AEC/329-02

**THE NORFOLK ARMS HOTEL, ARUNDEL.
LISTED BUILDINGS CONSENT ref: AB/23/16/L
APPLICATION to DISCHARGE CONSENT CONDITION 5.**

Further to our recent e-mail correspondence, and your discussions with the Historic Buildings Officer, Dr. Ian Wightman, I can confirm that this letter is part of a formal application to discharge Condition 5 of the Listed Buildings Consent ref: AB/23/16/L, for The Norfolk Arms Hotel, Arundel.

## STAIRWELL SCREEN ELEVATION PROPOSED 1:20.

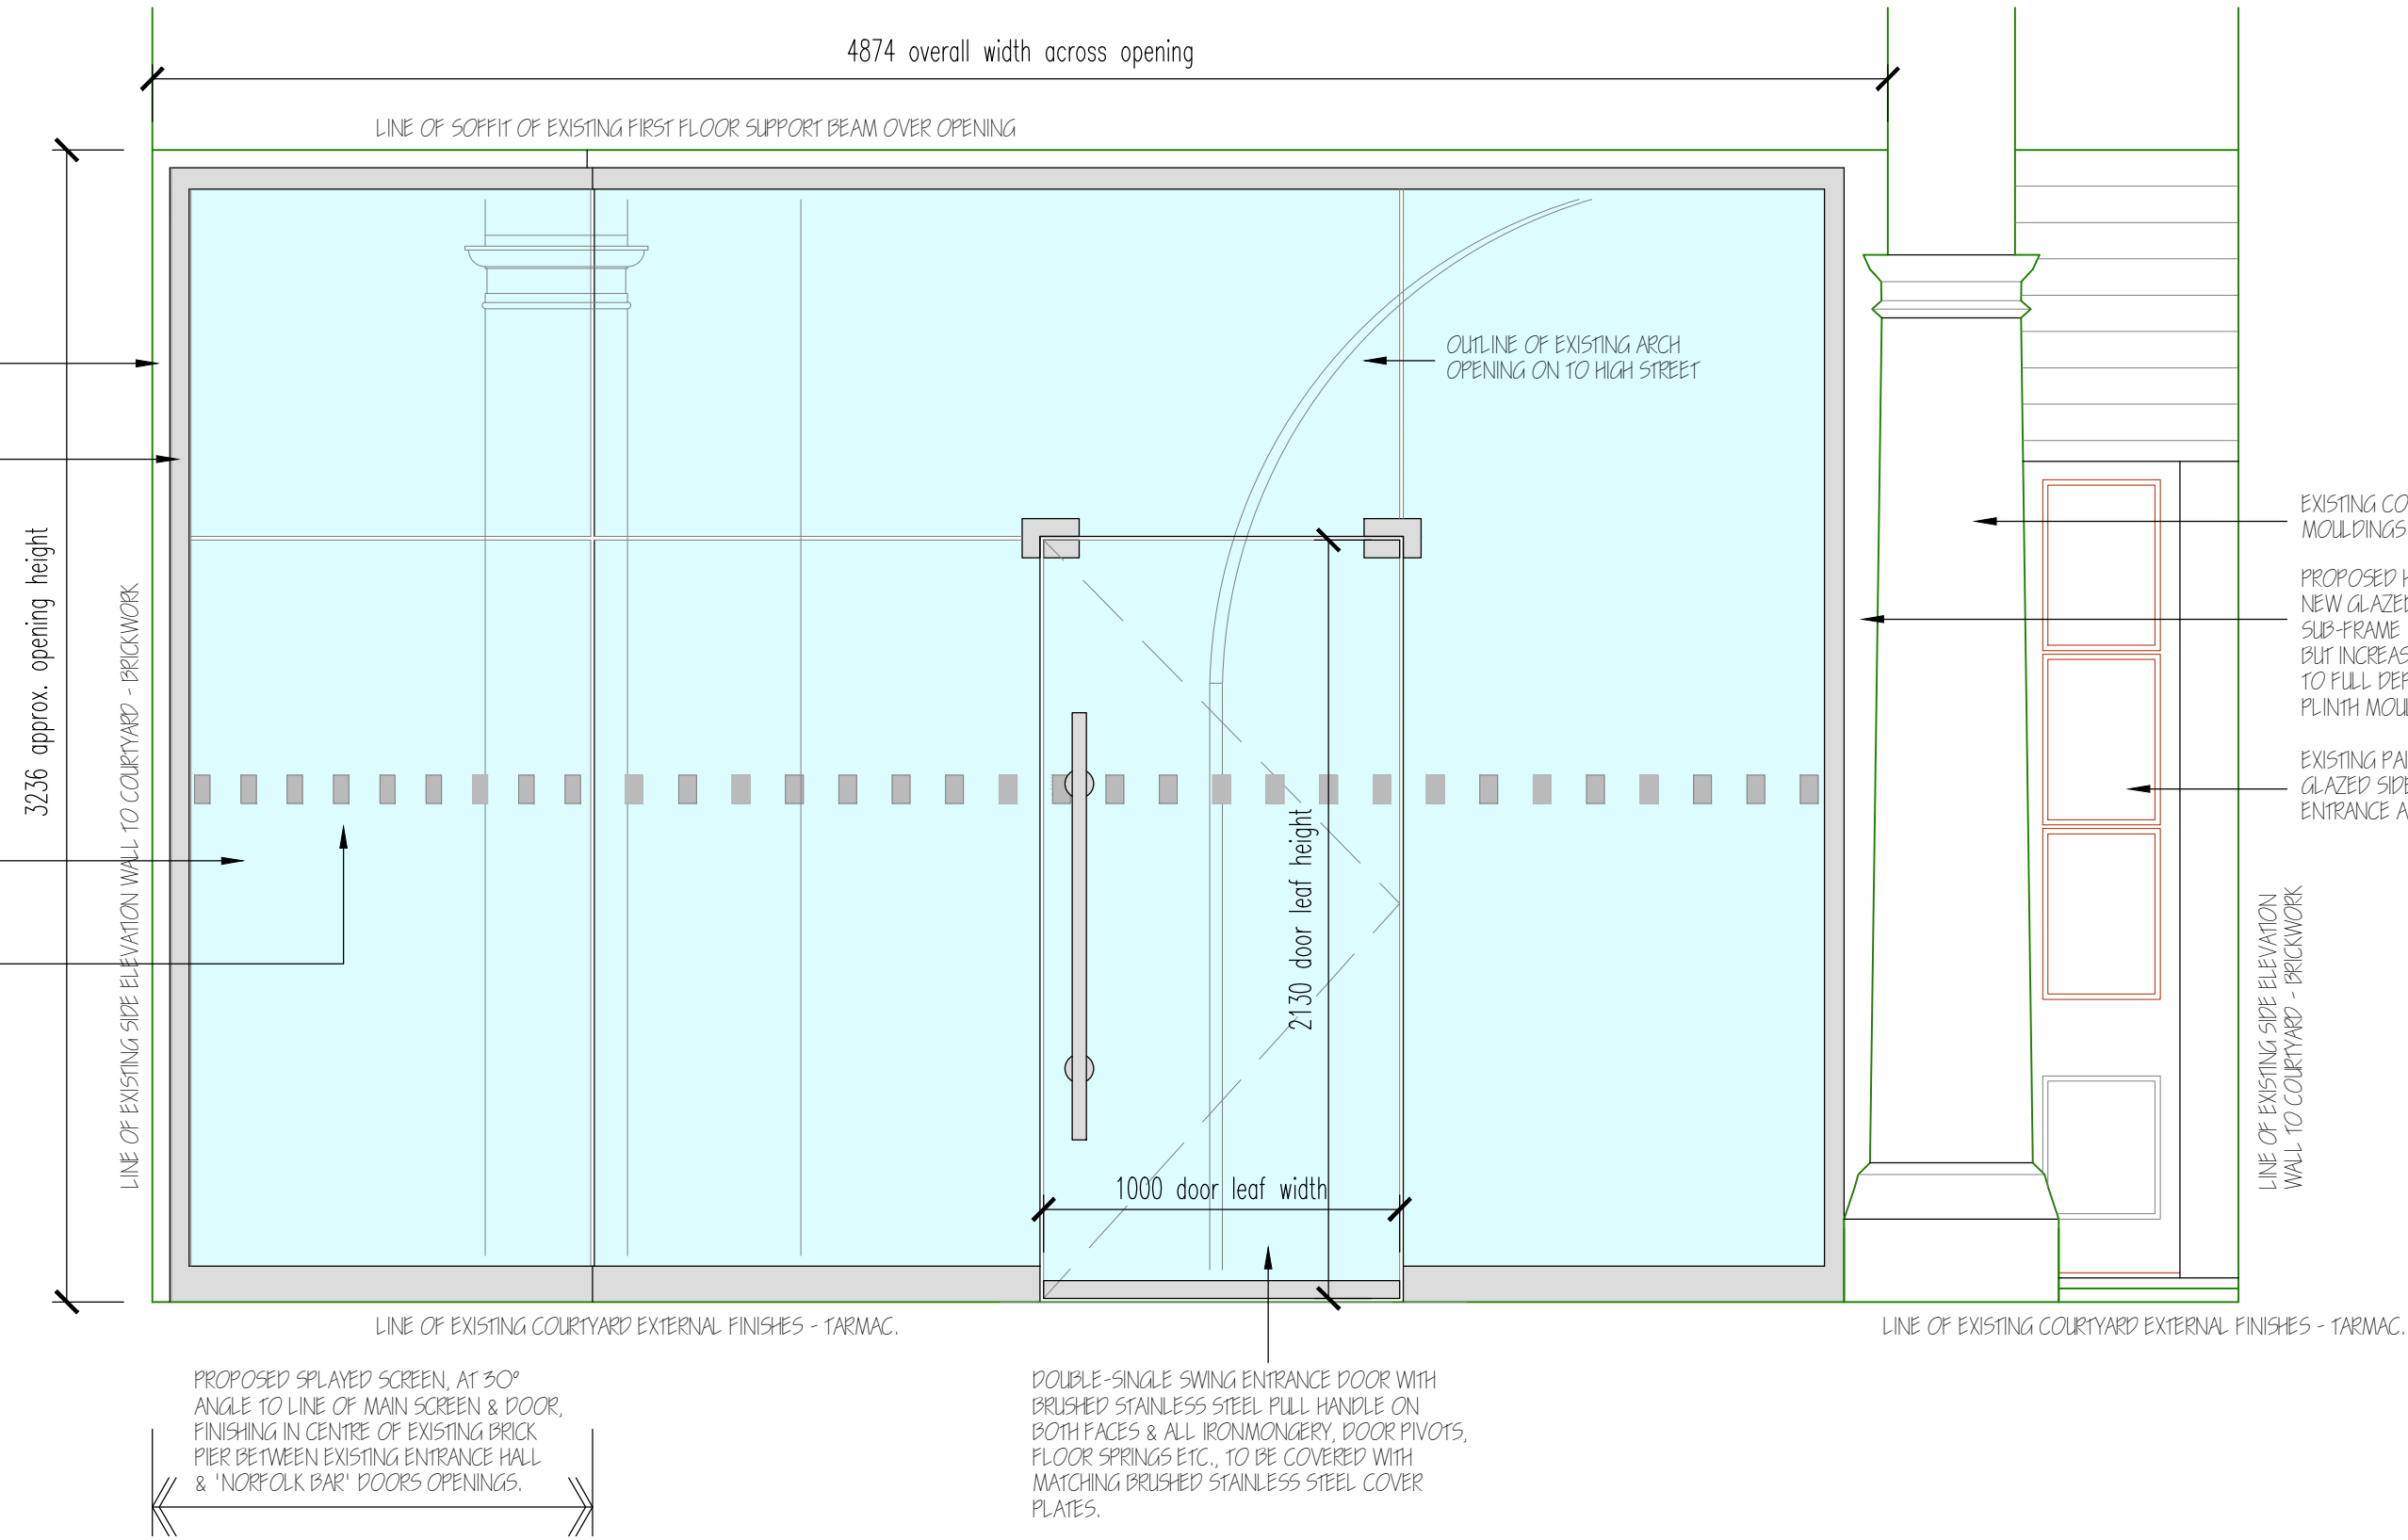
As a result, this Condition Release application proposes the installation instead, of 2no. ceiling-mounted 'fire curtains' within the Reception Corridor and rear Stairwell, which would enable the existing Reception entrance door & fanlight and the existing Stairwell glazed screen, glazed doors & fanlight etc. to be fully retained and unaffected.

Dr. Wightman was previously concerned also that the existing pair of glazed doors within the Stairwell glazed screen should not be replaced. The application drawings now show the existing pair of doors being retained and unaltered, except that they would need to be re-hung to open outwards, in the direction of emergency escape.

Under current Building Regulations, there is a requirement for '... the door of any doorway or exit should, if reasonably practicable, be hung to open in the direction of escape and should always do so if the number of persons that might be expected to use the door at the time of a fire is more than 60' (Building Regs. Part B, Vol.2, para 5.14).

The occupancy numbers of the Hotel guests and staff means that these doors would fall into the 'more than 60' category, hence the need to re-hang the existing door leaves within the existing frame.
